Response to Request for Information – Pymble Ladies College Secondary Innovation Precinct (SSD-79146716)

This letter has been prepared by Urbis on behalf of Pymble Ladies' College (**the Applicant**) in response to the NSW Department of Planning, Housing and Infrastructure (**DPHI**) request for information dated 11 February 2026. This RFI requested that the Applicant respond to the submissions received from Ku-ring-gai Council (**Council**) (dated 27 January 2025) and Department of Climate Change, Energy, the Environment and Water – Conservation Programs, Heritage and Regulation (**DCCEEW CPHR**) (dated 9 February 2026 and 27 February 2026) on the Response to Submissions package submitted by the Applicant in January 2026. The matters raised, and responses to each, are provided in **Appendix A**.

Figure 2: Location Plan featuring distances to Avon Road

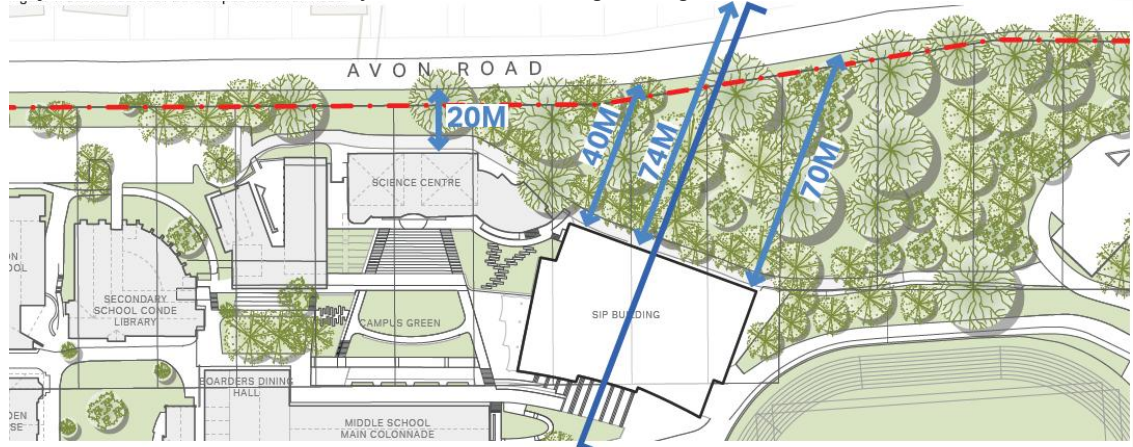
The western front corner of the proposed SIP building is setback 40 metres from the north-western boundary (Avon Road frontage), which is consistent with the setback of the north-eastern front corner of the existing Science Building. The Science Building adjacent to the proposed SIP building is highly visible from Avon Road.

The image provided at Figure 2 of Council's submission is not comparable to the setback and conditions proposed for the SIP building. Whilst the easternmost portion of the existing Science Building on the site is setback approximately 40m from the Avon Road frontage, (similar to the proposed SIP) this portion of the Science Building is similarly not visible from Avon Road, as it is heavily screened by existing trees, as demonstrated on page 3 of the Design Response prepared by 3XN at **Appendix B**.

The portion of the Science Building reproduced in the Council submission is also not screened by the dense trees forming part of the Lower Riparian Zone management area, unlike the proposed SIP building.

The majority of the SIP building will be setback greater than 40m from Avon Road and will be screened by dense, mature tree coverage, resulting in the development

being minimally visible from Avon Road. Visual impacts are further minimised by the significant separation distances to the nearest residential dwellings across Avon Road (approximately 70m-100m separation), as well as the oblique viewing angles of the SIP building from the public domain. Given this context, the building will not present with the same level of prominence as the existing Science Building.	
While trees within the proposed 'Lower Riparian Zone' are to be retained, the visual impact of the proposed development should not rely on vegetation for screening. As such, concerns remain regarding the lack of articulation or modulation to reduce its visual bulk on the northern façade of the six-storey building, which fronts Avon Road and adjacent R2-zoned low density residential dwellings along Avon Road.	The visual impact of the proposed development should be assessed based on the full streetscape context, including the existing, mature vegetation on the site. This vegetation is not proposed as mitigation for the purposes of visual impact but rather forms an important part of the established and permanent landscape setting of the site. It provides extensive screening which will result in the SIP building being minimally visible from Avon Road. This is demonstrated clearly by the visualizations prepared by 3XN which were submitted at Appendix C of the Response to Submissions package. Moreover, the northern façade of the proposed building is broken into three distinct vertical components with glazed strips providing visual separation, and continuous horizontal sunshades provided to all levels. The northern façade will also include detailed brickwork to create further visual interest. Refer to Appendix B for further detailed assessment.	Appendix B
